STATE OF NORTH CAROLINA
DEPARTMENT OF TRANSPORTATION

July 29, 2014

SUBJECT: **Additional Information for the Section 404 Individual Permit Application and Request for Modification to the Section 401 Water Quality Certification** for the proposed NC 24/27 Troy Bypass from west of SR 1138 (Dairy Road) to just east of Little River, Montgomery County, Division 8. WBS Element No. 34352.1.1, TIP No. R-0623.

REFERENCE: R-0623 Individual Permit Application, dated March 10, 2014
NCDWR Project No. 2014-0285, Certification No. 3992, dated May 23, 2014.

PERMIT DRAWING
SHEET 40 OF 91

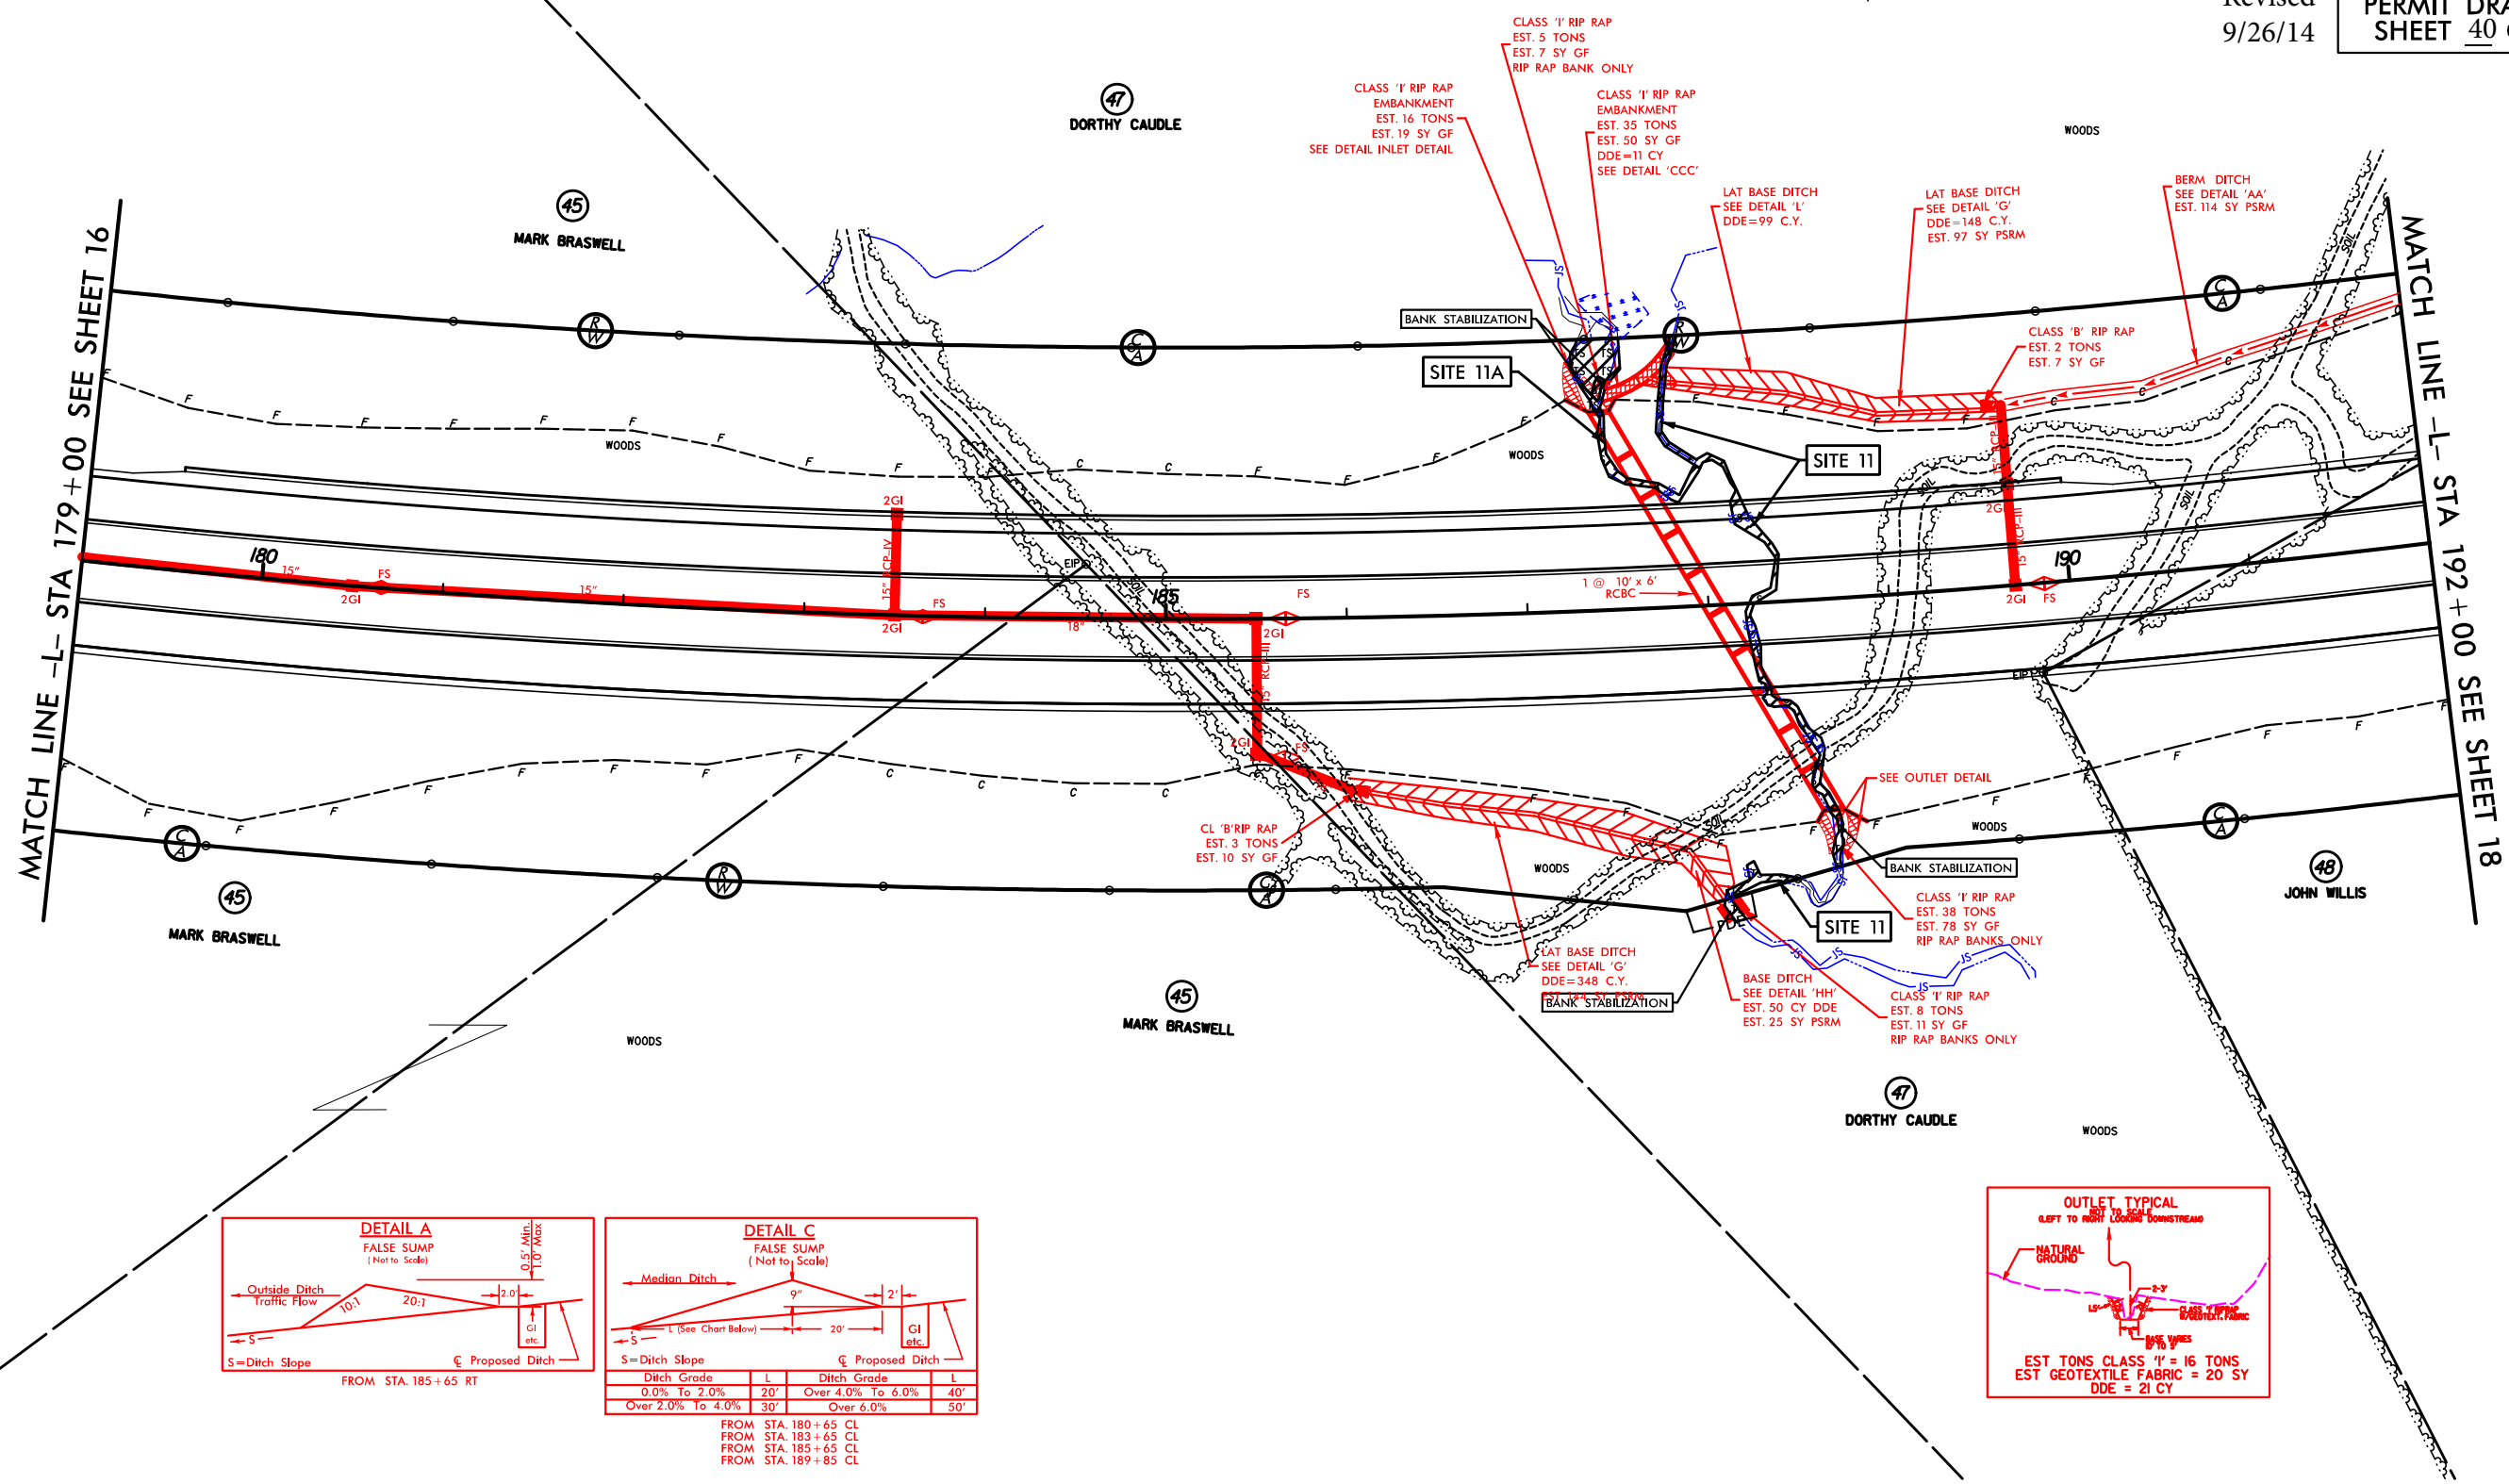
Changes in stream impacts for Permit Sites 11 and 11A are associated with the recent design change of the proposed pipe to box culvert. Permanent stream impacts (fill) will decrease from 322 linear feet to 319 linear feet for Permit Site 11 while bank stabilization will increase from 15 linear feet to 47 linear feet. Temporary stream impacts at Permit Site 11 will decrease from 83 linear feet to 56 linear feet. Permanent stream impacts (fill) will increase from 91 linear feet to 105 linear feet at Permit Site 11A while bank stabilization will increase from 0 linear feet to 6 linear feet. Temporary stream impacts at Permit Site 11A will decrease from 41 linear feet to 21 linear feet. These revised impacts for Permit Sites 11 and 11A are shown in the attached Revised Permit Drawing Sheets 40-43 of 91, and 90 of 91, and in Table 1 below in bold and italicized font.
